Phone: 0300 123 6780
Email: developeras@lancashire.gov.uk
Your ref: 3/2025/0530
Our ref: 3/2025/0530/HDC/KW
Date: 05 August 2025

Location: Coxes Farm Stoneygate Lane Ribchester PR3 2ZS
Proposal: Proposed erection of a timber-framed agricultural building with stable.
Grid Ref: 364735 437460

Lancashire County Council acting as the Local Highway Authority does not consider that the application as submitted fully assesses the highway impact of the proposed development and further information is required as set out in this response.

Block Plan-0.S Map

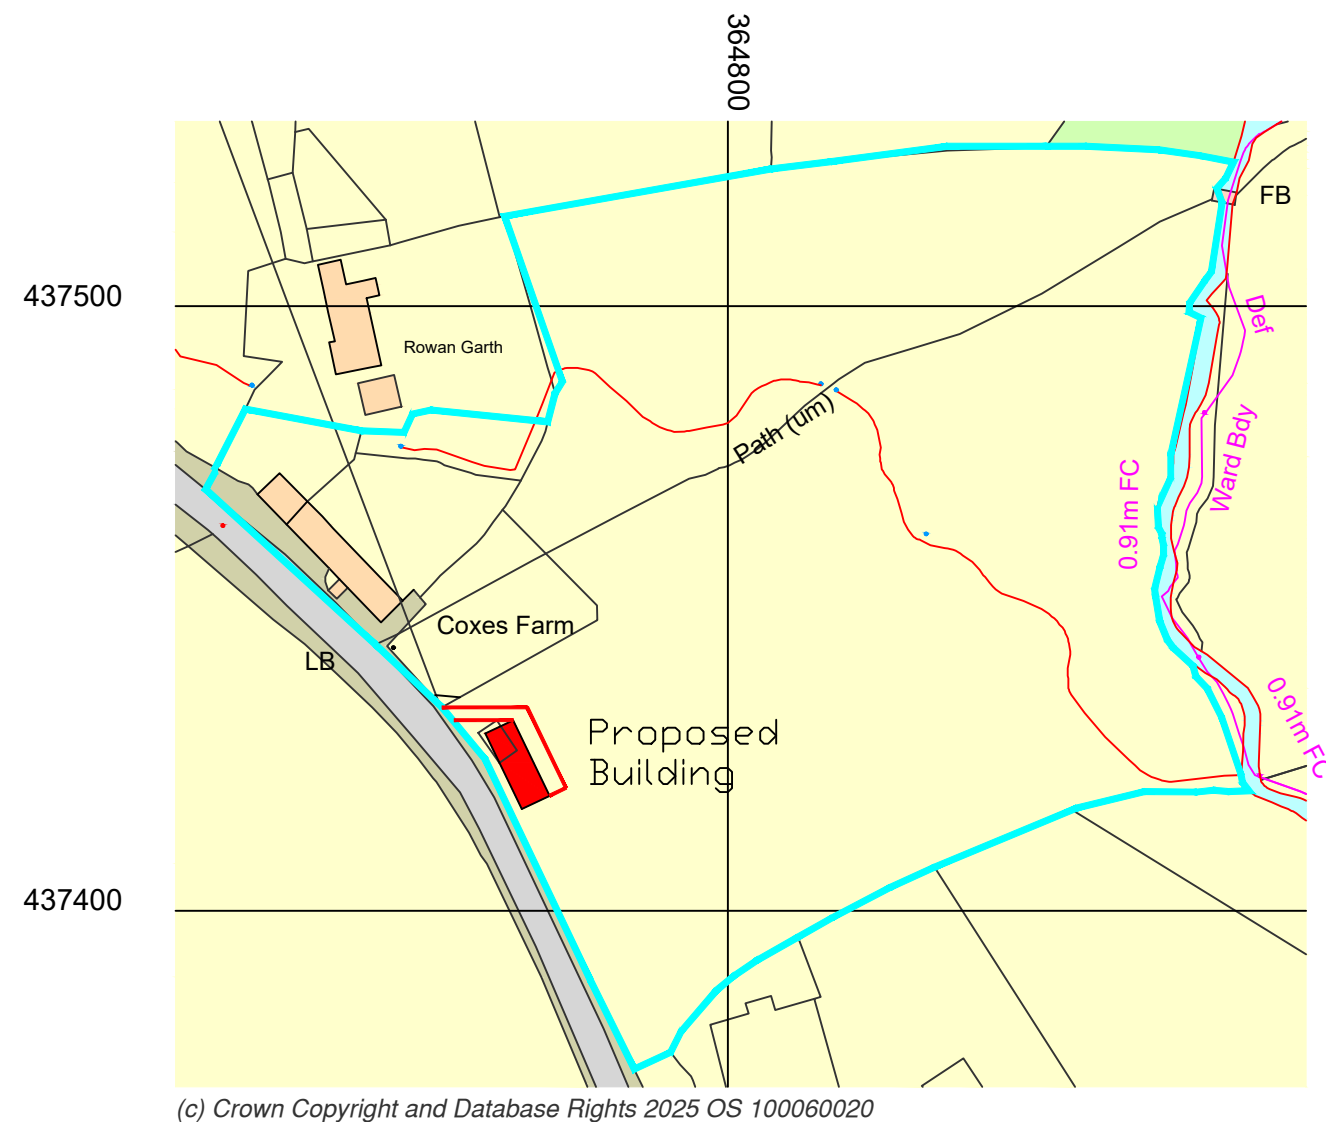
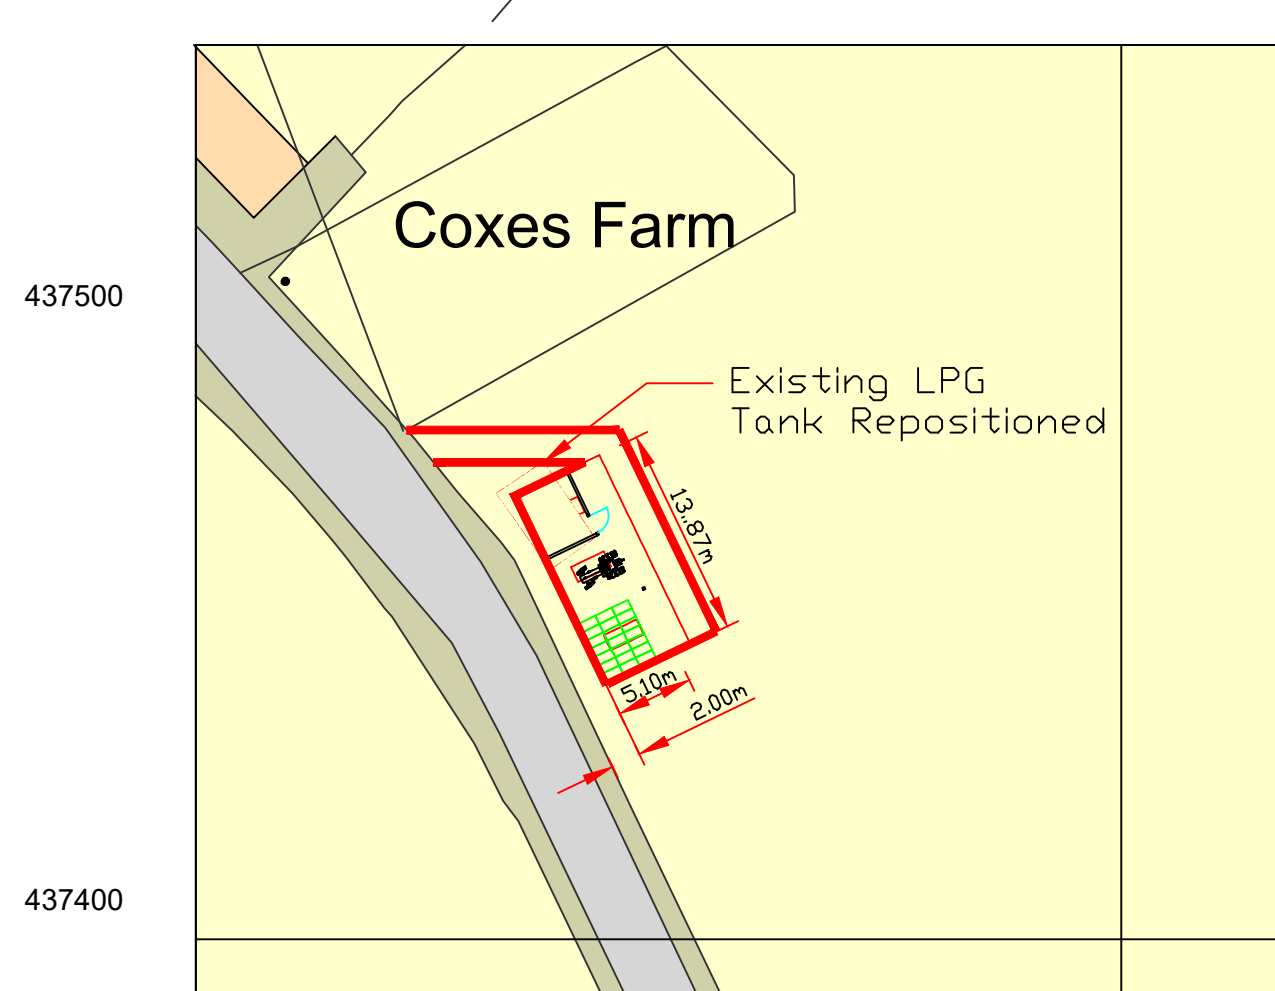
Before the LHA can fully assess whether the access and internal layout complies with the LHAs guidance, the LHA require a detailed site access plan to be submitted. On the drawing the LHA require the access width to be shown, the LHA would normally require agricultural accesses to be at least 6m wide.

The LHA would expect the access to be hard surfaced extending from the adopted highway boundary for a minimum distance of 10m into the site, this shall be appropriately paved in tarmac, concrete, block paviours, or other hard material to prevent debris from being deposited onto the highway.

There is currently no vehicle crossing situated at the access as noted on site. An appropriate agreement will need to be entered into by the applicant in order to create an appropriate crossing over the existing verge to the carriageway as the current access is a field gate.

Acceptable visibility splays need to be provided at the proposed access, these either need to be in line with the Design Manual for Roads and Bridges (DMRB), CD123, Chapter 3 which would require a splay 2.4 metres back from the near edge of the carriageway and extending 215 metres along the nearside carriageway edge in both directions on a 60mph classified road such as Stoneygate Lane. Or the visibility splay will need to be based on the 85th percentile speeds from a full weeks survey undertaken in a neutral month. The traffic study would need to be carried out by a recognised professional data collection company showing the 85th percentile road traffic speeds in both directions the numbers of vehicles, types of vehicles and the speed of vehicles passing the access.

The visibility splay should be wholly within the land which the applicant controls and/or the adopted highway and nothing should be erected, retained, planted and / or allowed to grow at or above a height of 0.9 metres above the nearside carriageway level which would obstruct the visibility splay of the proposed access.

The gate will also be required to be positioned at least 10m back into the site to allow for agricultural vehicles to pull clear of the carriageway before operating the gate to remove any conflict between turning vehicles and vehicles travelling within the carriageway.

The LHA are also aware that no parking or turning plan has been submitted to support the application. Consideration should be given to a formalised turning area for the largest vehicles accessing the site. A detailed plotted swept path analysis is likely to be required showing the largest vehicle accessing the site as well as a swept path showing a turning area is adequate for the types of servicing vehicles which service the site.
